**S.4.55(1A) MODIFICATION 3, SSD-66777221 – LANCELEY PLACE DATA CENTRE,
MINOR ARCHITECTURAL PLAN MODIFICATION**

This is the **third (3rd)** modification to SSD-66777221 and **seeks minor architectural updates to the switch room and reinstatement of a Lanceley Place crossover.**

DRAWING TITLE
AXO VIEWS

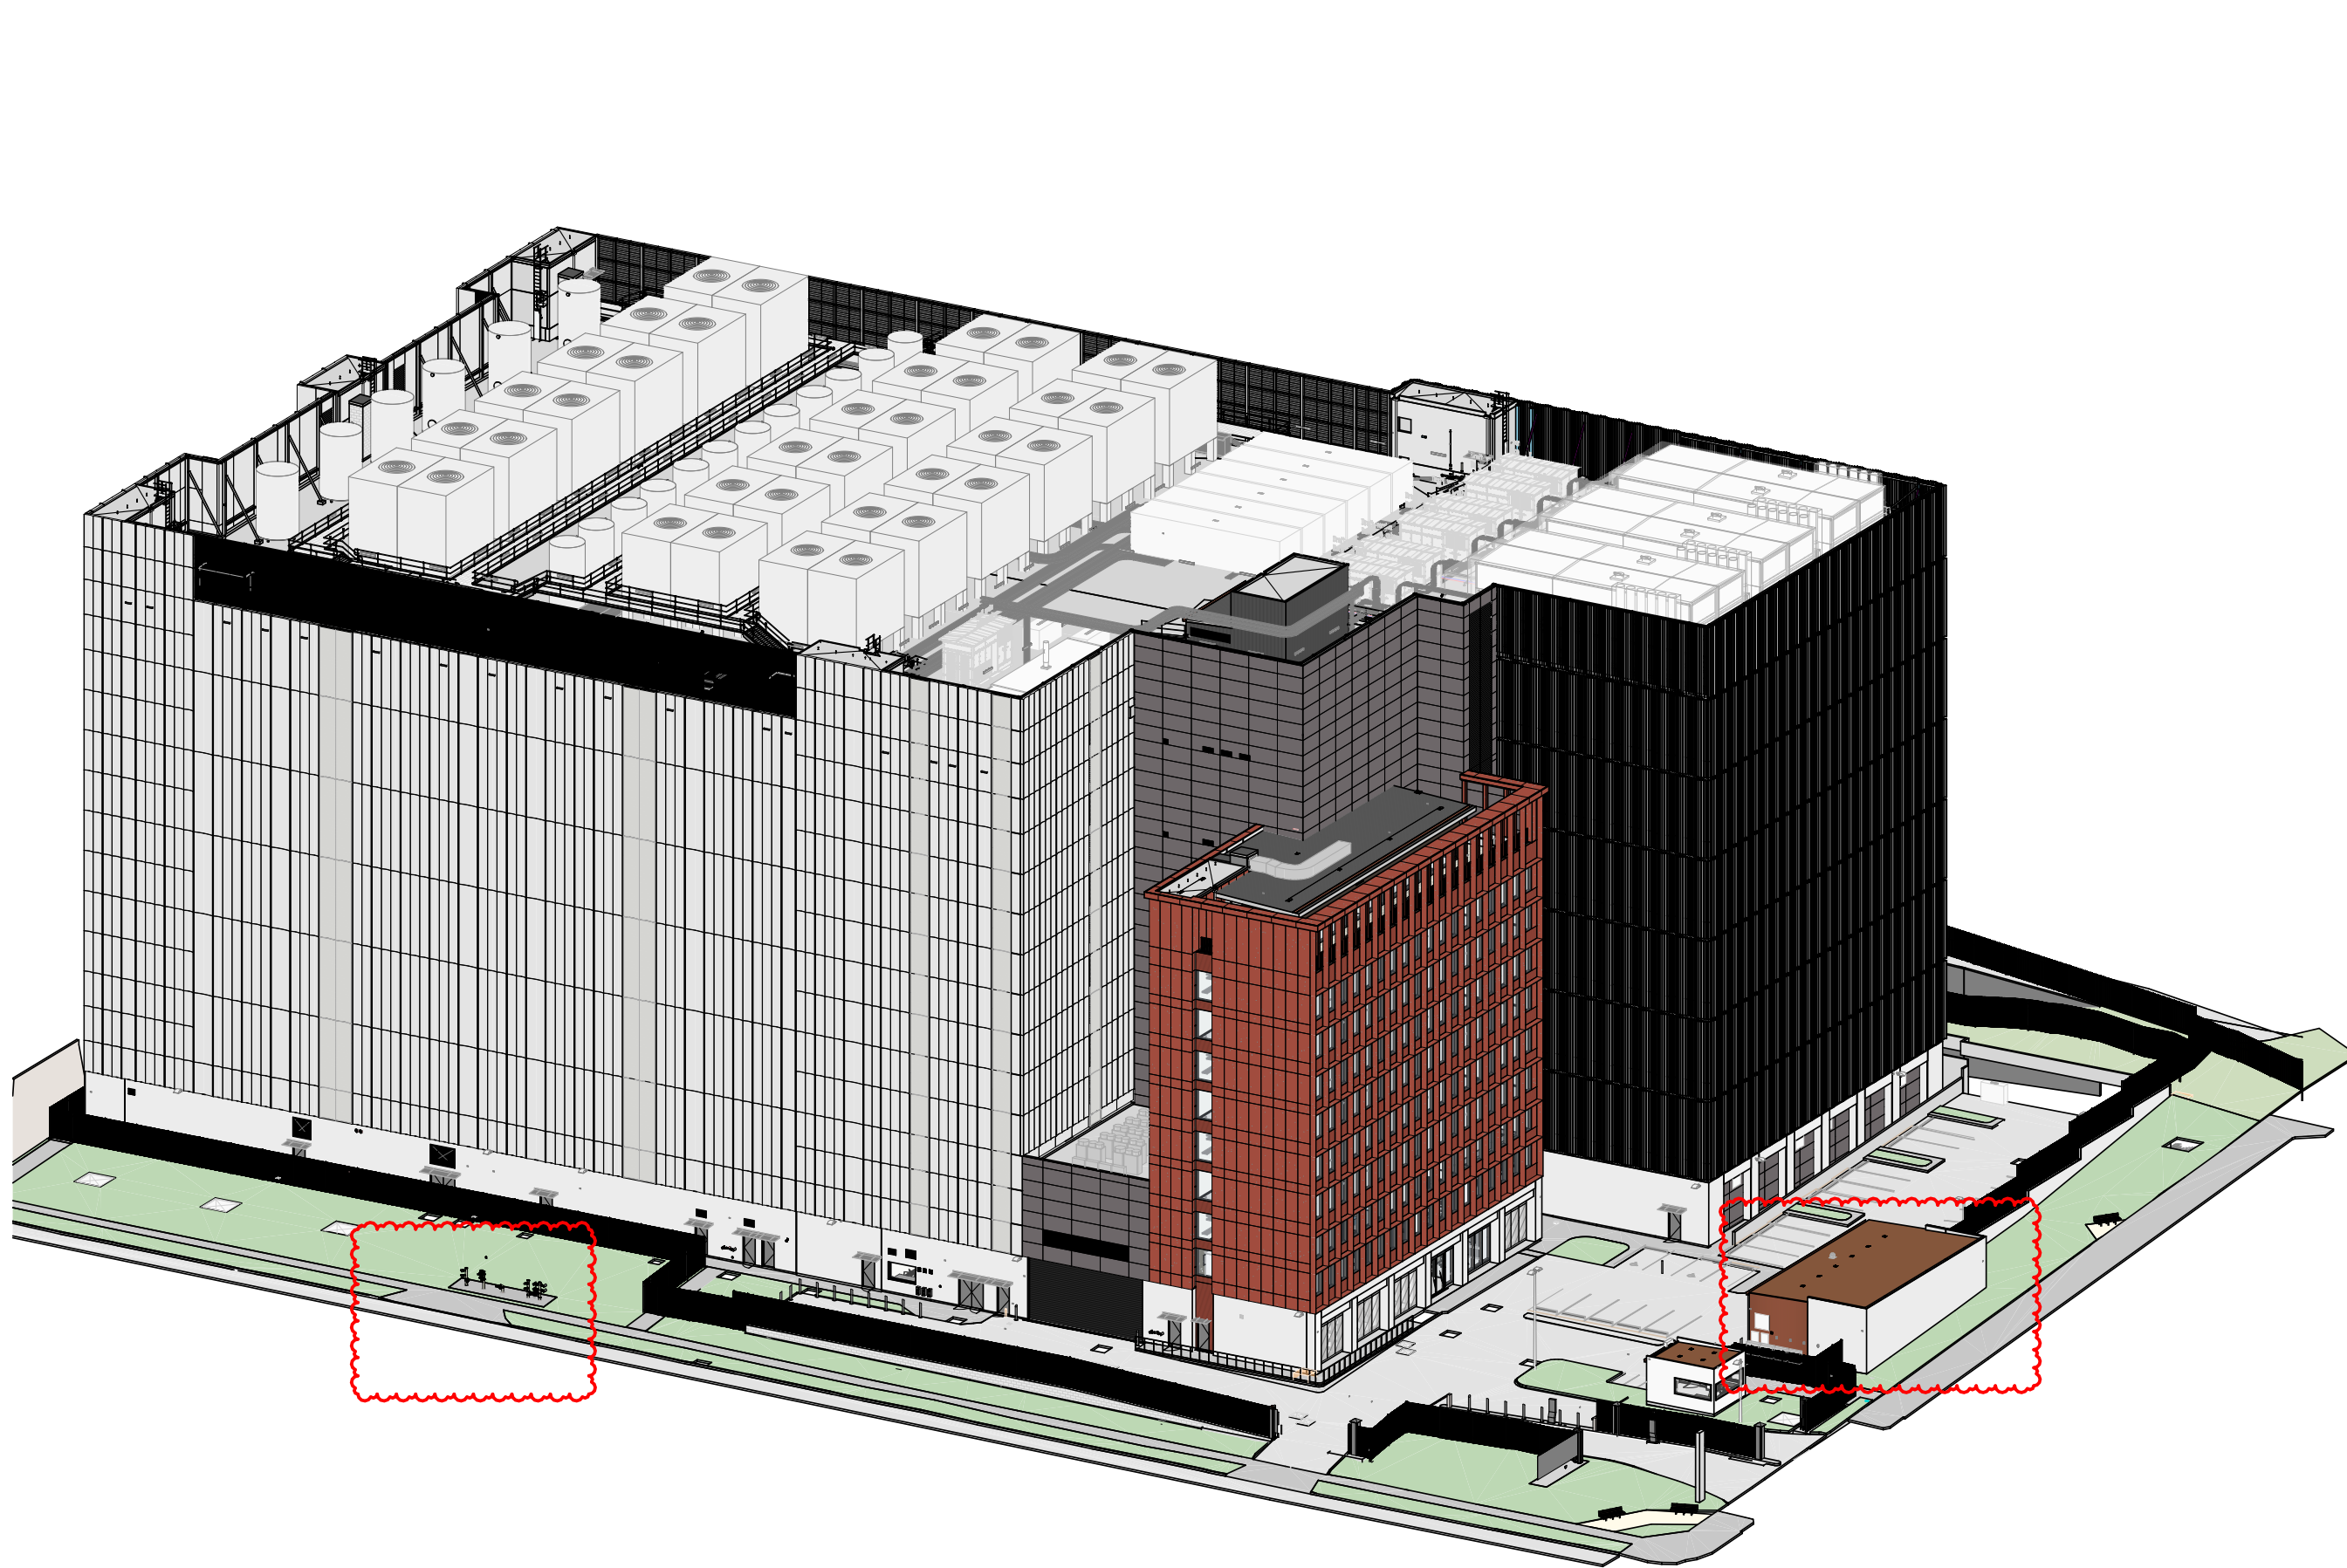
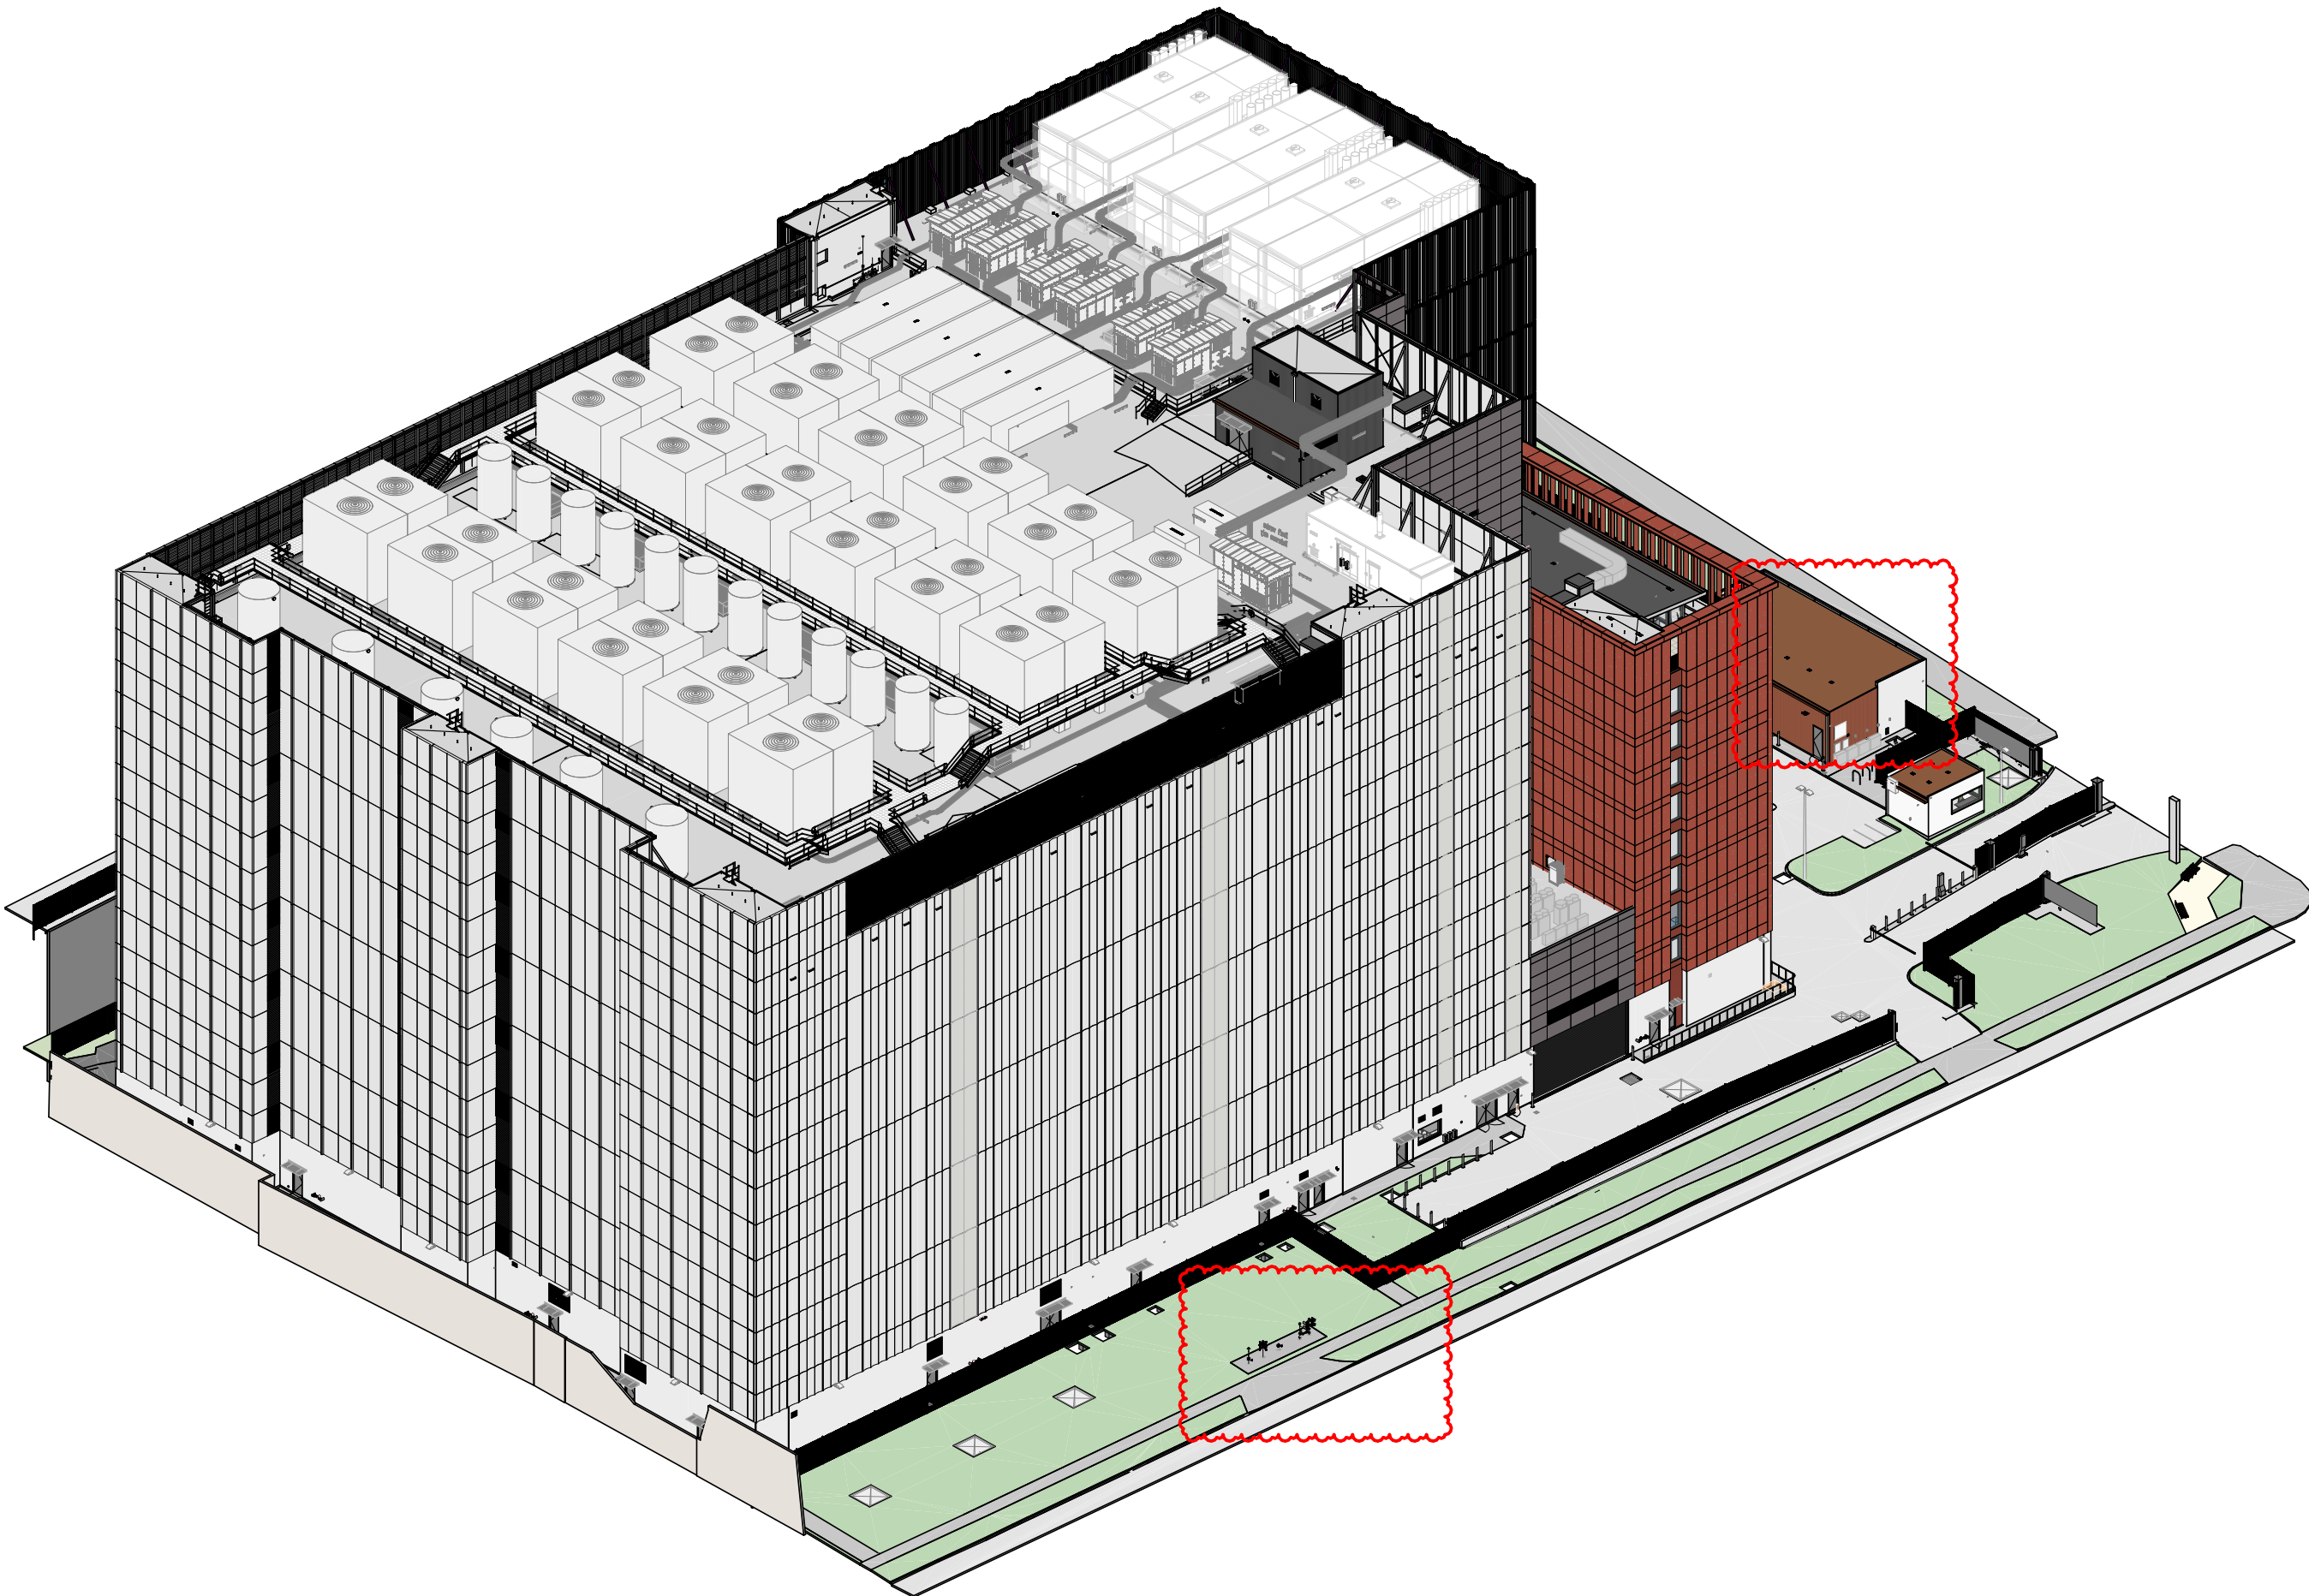
Increase the height of the external switch room located along the site's southern frontage to Campbell Street from 4.045m to 5.250m, an minor increase of 1.205m.

The approved switch room height was based on generic, vendor-neutral air insulated switchgear. GPSA has now selected Eaton gas insulated switchgear (GIS), which is slightly taller than originally assumed. As a result, an extra 1.205m of vertical clearance is needed to allow components to be replaced from the top and rear.
